WALDEN PRESERVE 2 Filing No. 4 Grading & Erosion Control Plans El Paso County, Colorado

PCD FILE NO. SF-18-034

TITLE SHEET

SITE GRADING & EROSION CONTROL PLAN

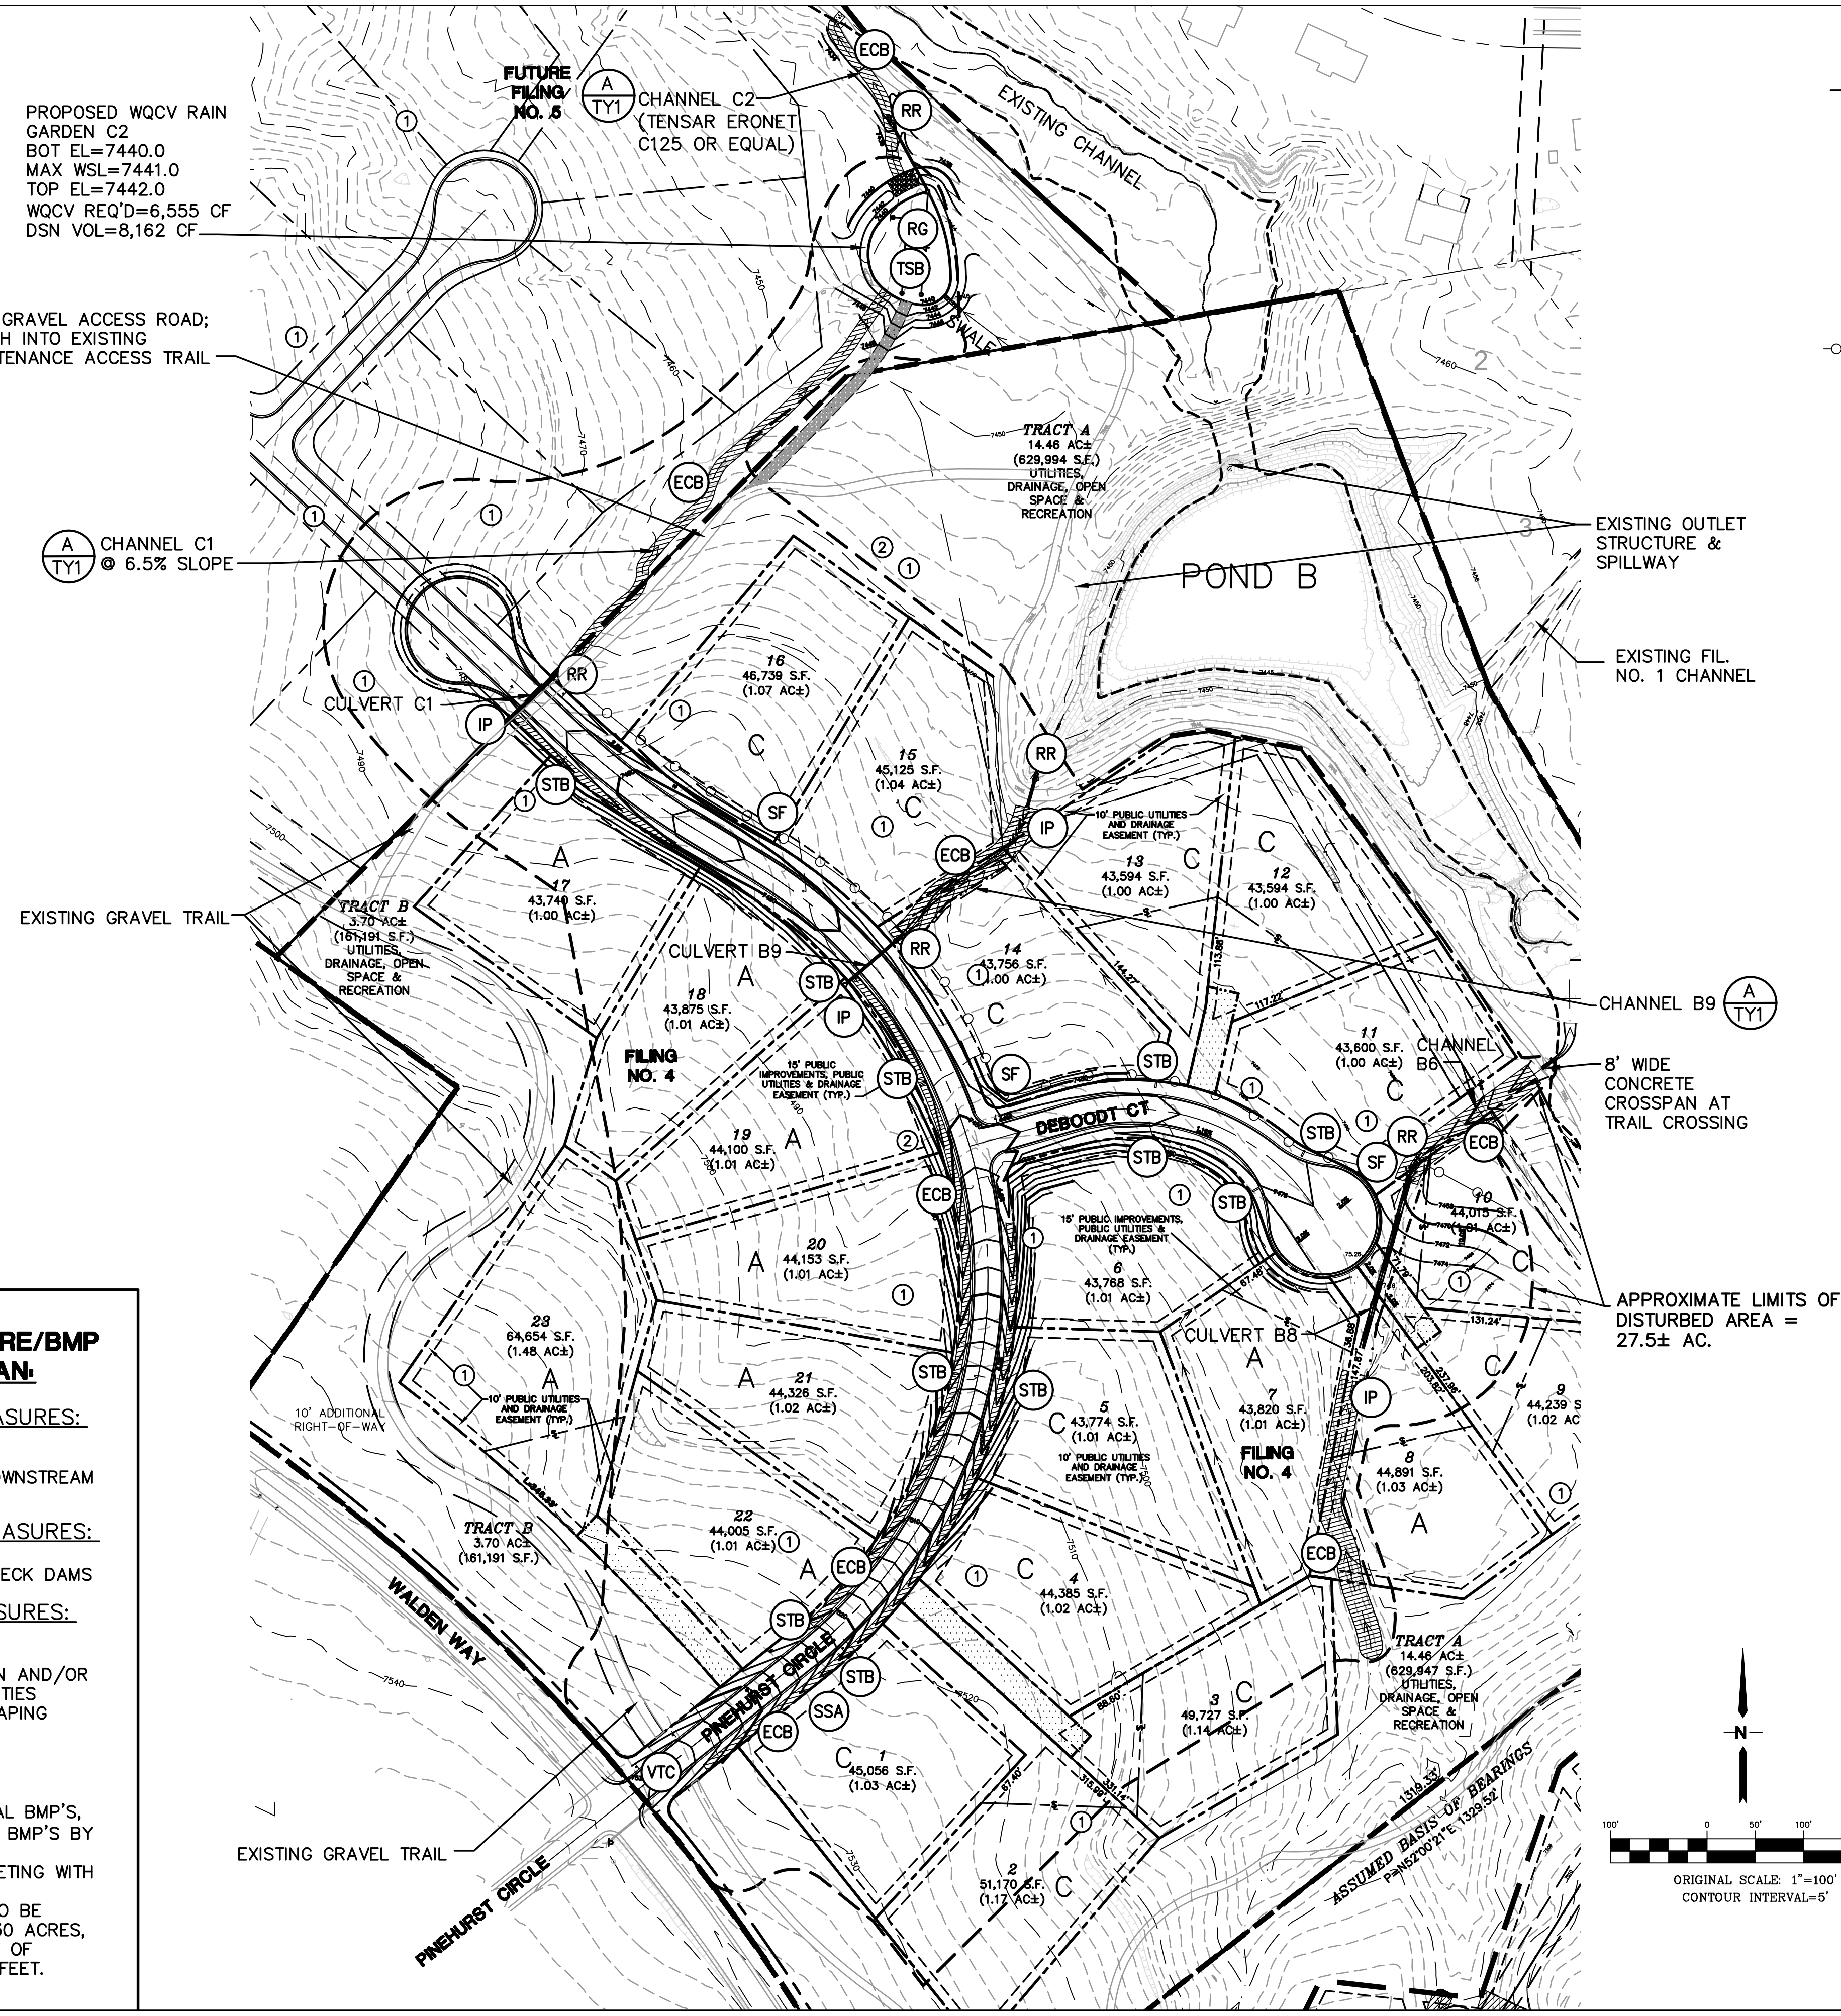
Temporary Sediment Pond is missing in the phasing plan
